Development Demolition of existing dwelling (No. 32) & erection of 4 No. 4 bed dwellings, alterations to existing dwelling (No. 34A) with alterations to two existing accesses to form a single point of access. This application may affect the Ferring Conservation Area.

Location 32 & 34A Sea Lane Ferring

I regret that I am unable to accept your documents as a formal application until the following item(s) have been received or resolved :-

PLOT 2 - Plans and elevations of existing house

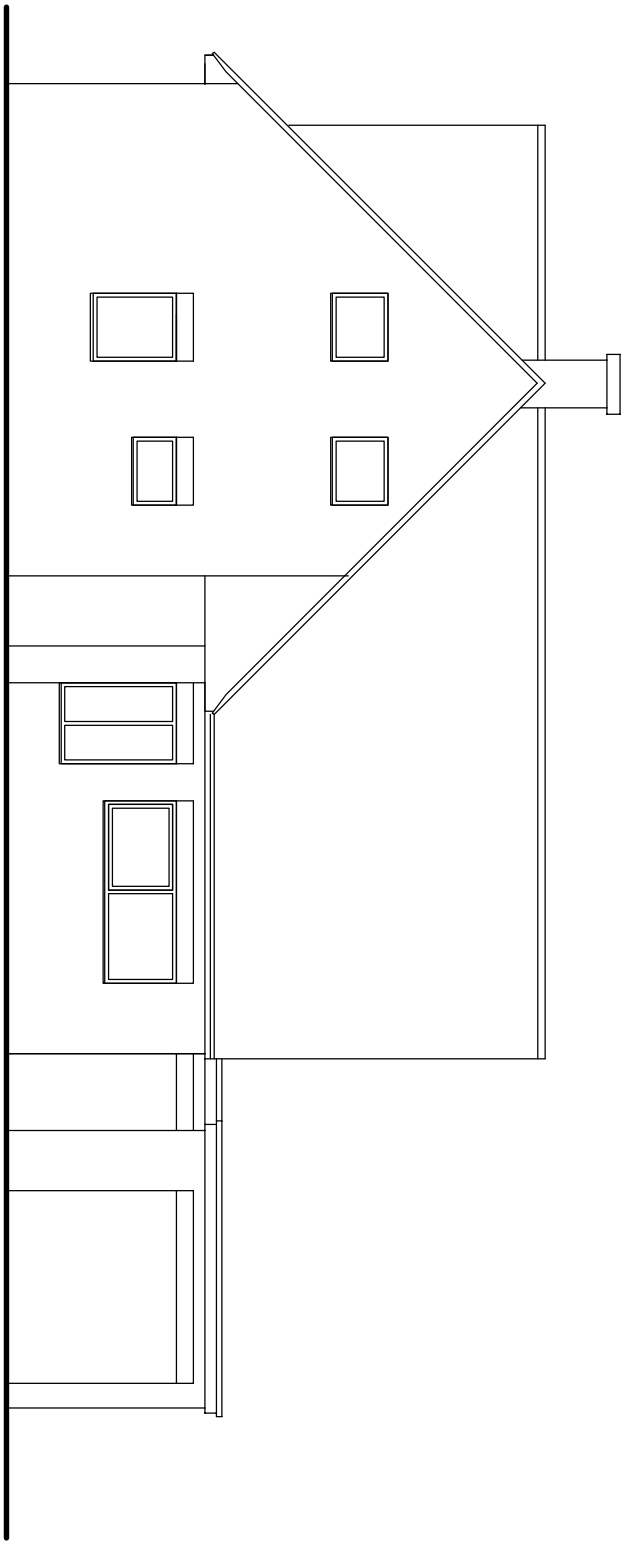
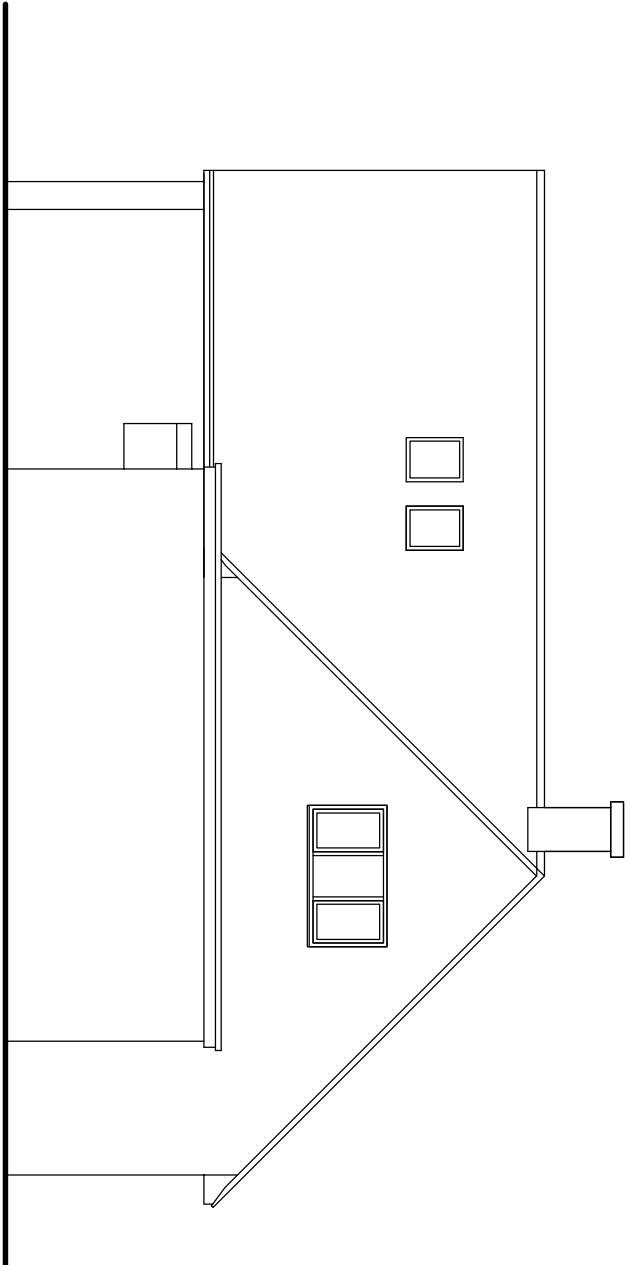
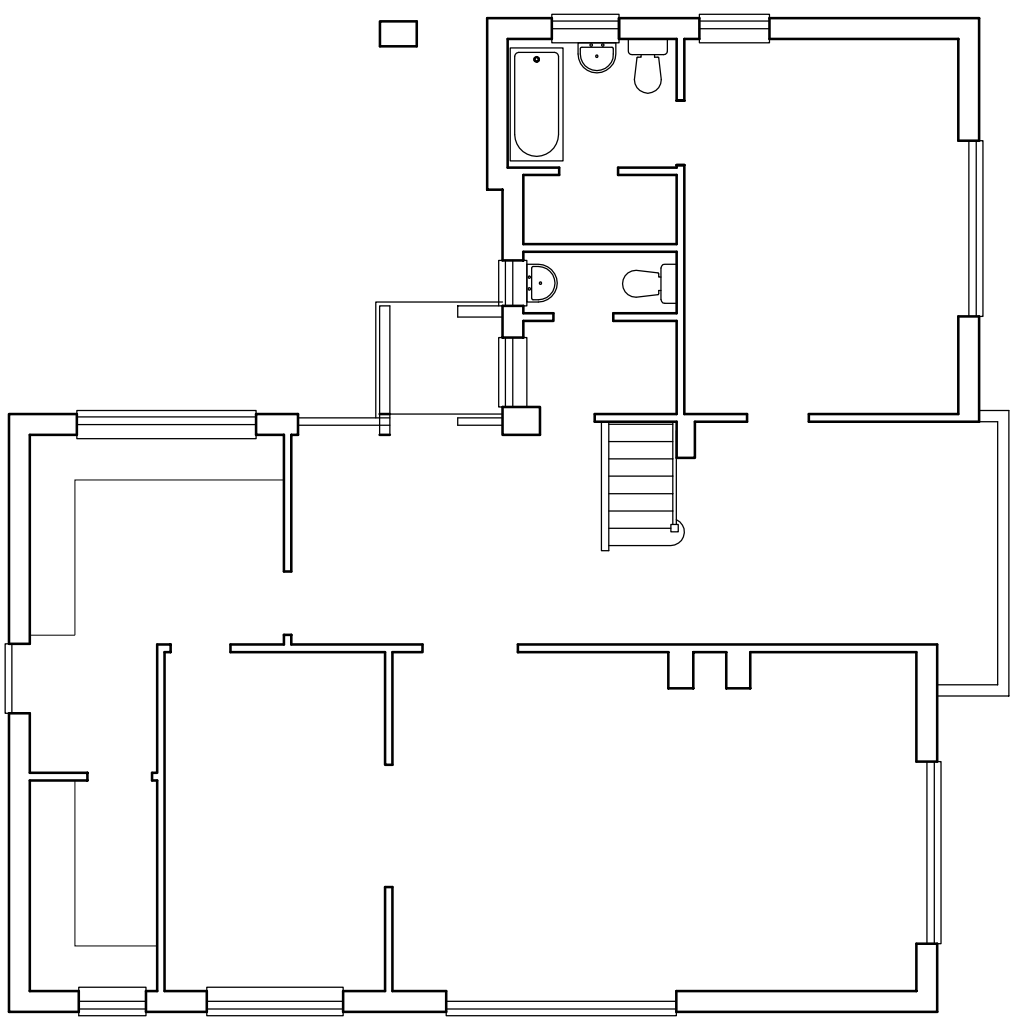
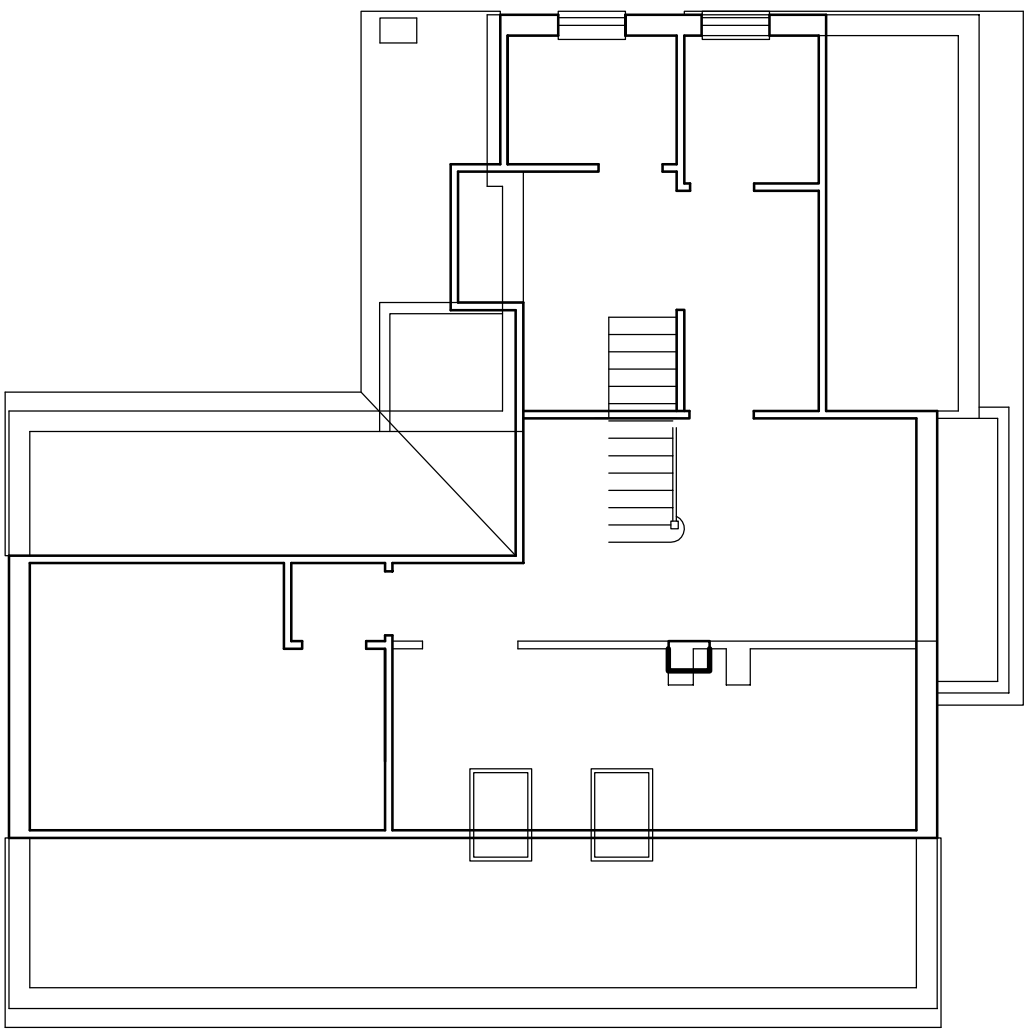
The existing east ground and first floor plans and elevations do not accord on Plot 2. Please amend accordingly.

The existing west first floor plan and elevation do not accord on Plot 2. Please amend accordingly.
